**KIRKLEES METROPOLITAN COUNCIL
INVESTMENT & REGENERATION SERVICE**

**DELEGATED DECISION FOR DISCHARGE OF CONDITION A.4 -
NOTIFICATION OF A PROPOSED ENLARGEMENT TO DWELLINGHOUSE**

Reference no.	2019/HH/94078/E
Site Address	2, Elm Way, Birstall, Batley, WF17 0EQ
Description	The proposal is for a single storey rear extension. The extension projects 4m beyond the rear wall of the original dwellinghouse. The maximum height of the extension is 2.8m. The height of the eaves of the extension is 2.55m.
Recommending Officer	Olivia Roberts

DECISION - REFUSAL

as proposed

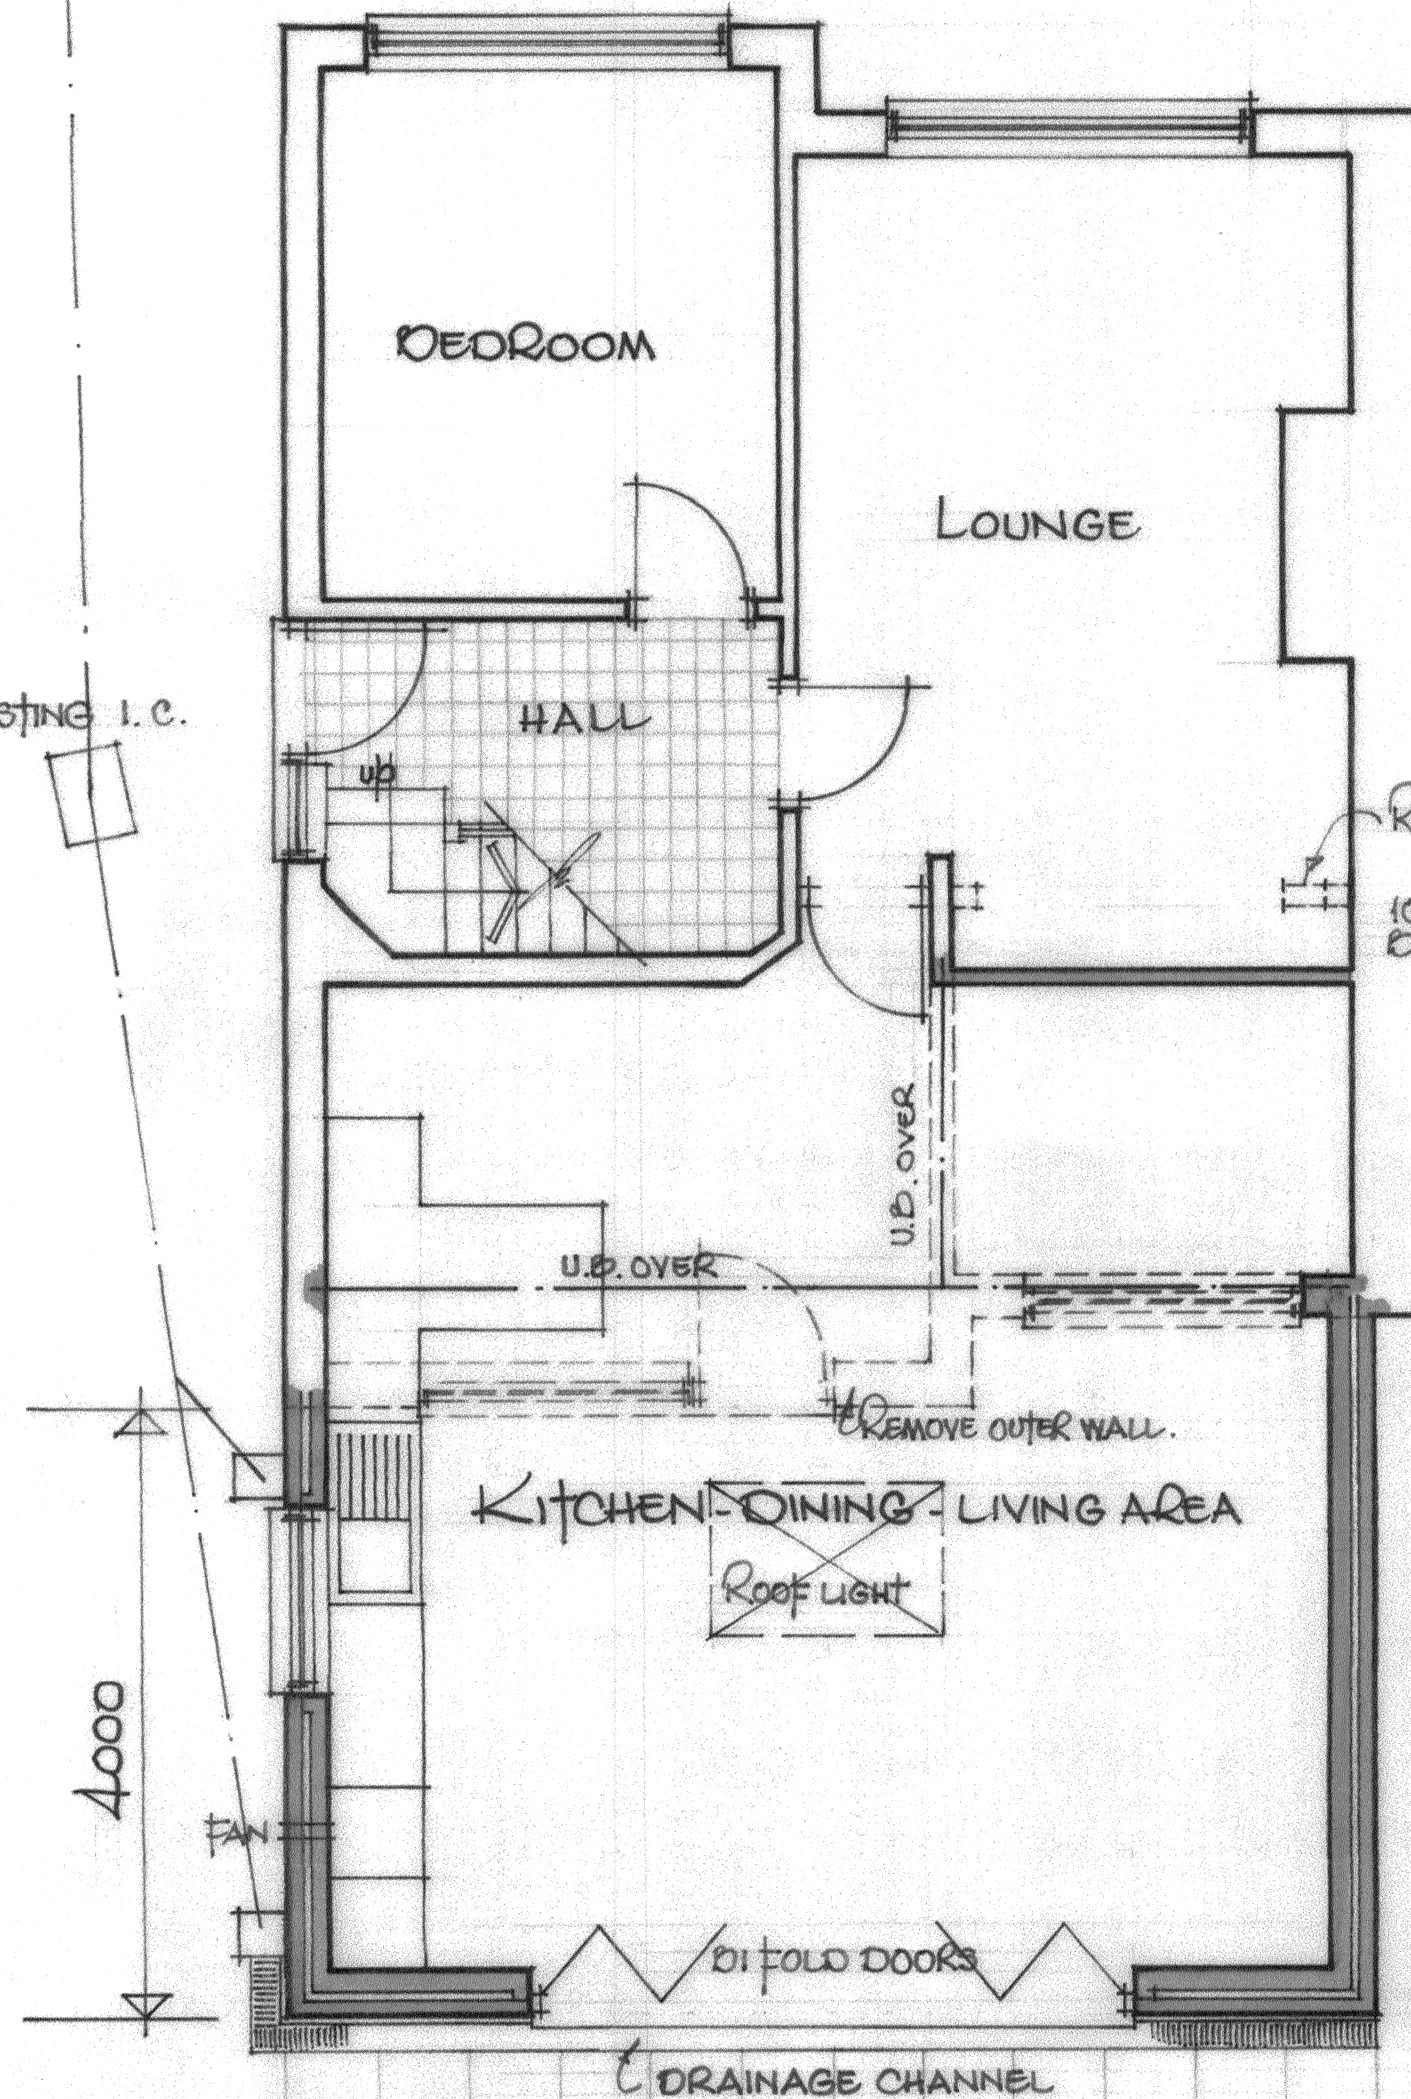
The property is designed with a staggered gable roof form with the existing kitchen projecting an additional 0.60 metres to the rear than the rest of the dwelling. After a review of historic maps, it has been noted that this is part of the original design of the property. The proposal therefore extends beyond the side elevation of this original part of the dwellinghouse and would have a width greater than half the width of the original dwellinghouse. As such, the proposal exceeds the limitation in paragraph A.1 (j) of Class A, Part 1, Schedule 2 of the Town and Country Planning (General Permitted Development)(England) Order 2015 (as amended).

Within Class A, Part 1 of Schedule 2 of the Town and Country Planning (General Permitted Development) (England) Order 2015 (as amended) paragraph (j) states that development is not permitted if “the enlarged part of the dwellinghouse would extend beyond a wall forming a side elevation of the original dwellinghouse and would – (iii) have a width greater than half the width of the original dwellinghouse”.

The proposed extension would extend from the original side wall of an existing projection on the property and would exceed half the width of the original dwellinghouse. The eaves height of the extension would also exceed that of the host dwellinghouse. The proposal therefore fails to meet the criteria of the General Permitted Development Order 2015, Schedule 2, Part 1, Class A paragraph (d) and paragraph (j).

SIDE ELEVATION

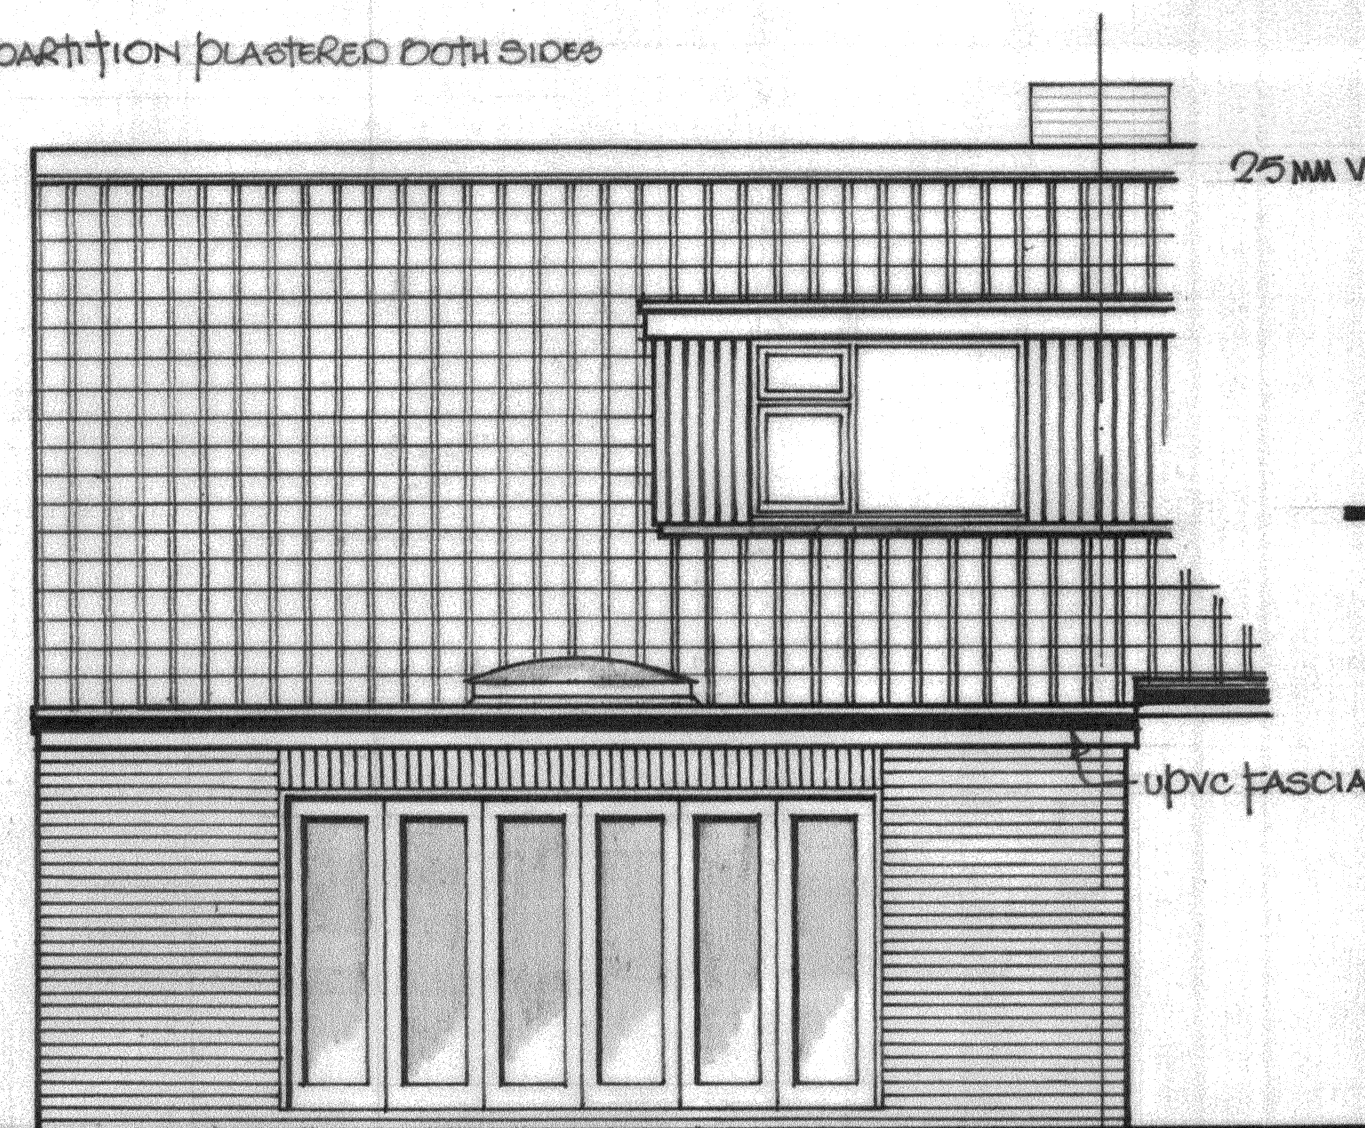
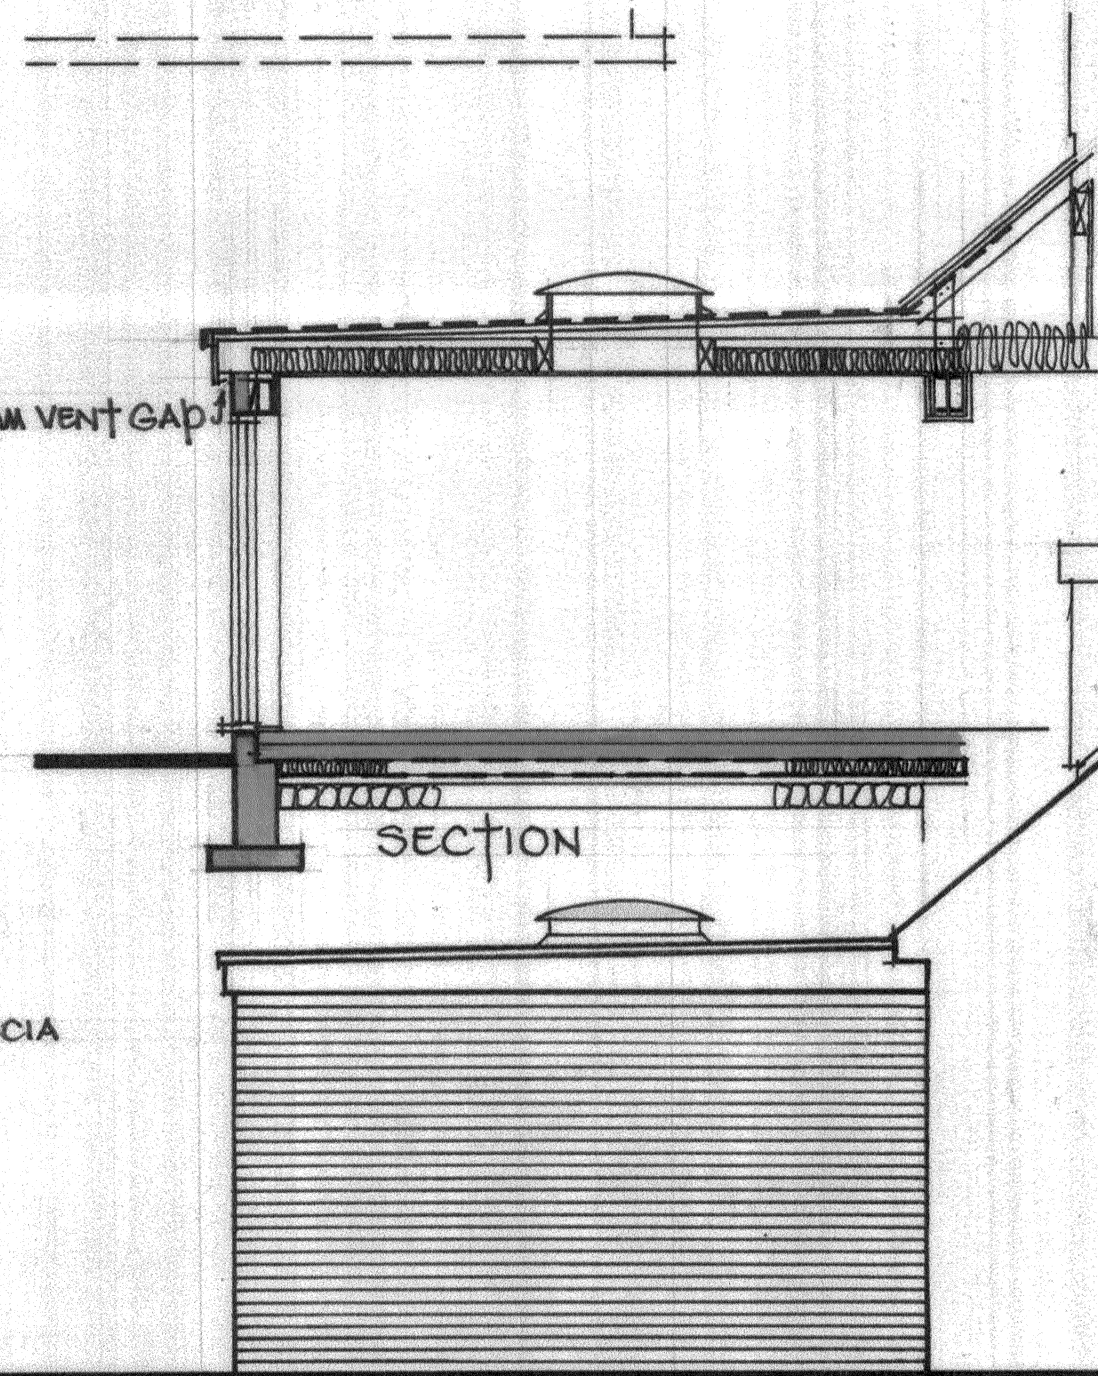
Is the site within a Conservation Area, Article 4 or SSI area?	No
Is any part of the proposal clearly outside the curtilage of the dwellinghouse?	Yes – Whilst the submitted block and floor plans show the extension within the curtilage of the dwellinghouse, the submitted elevations appear to show to extension projecting beyond the boundary to the south west
If the house is detached and from the information submitted, does the extension extend more than 8 metres from the rear of the original dwellinghouse?	N/A
If the house is not detached and from the information submitted, does the extension extend more than 6 metres from the rear of the original dwellinghouse?	No
Does the proposal exceed 4 metres in height?	No

In addition, from the submitted elevation plans, it is evident that the eaves height of the extension would exceed that of the original dwellinghouse. As such the proposal would exceed the limitation in paragraph A.1 (d) of Class A, Part 1, Schedule 2 of the Town and Country Planning (General Permitted Development)(England) Order 2015 (as amended).
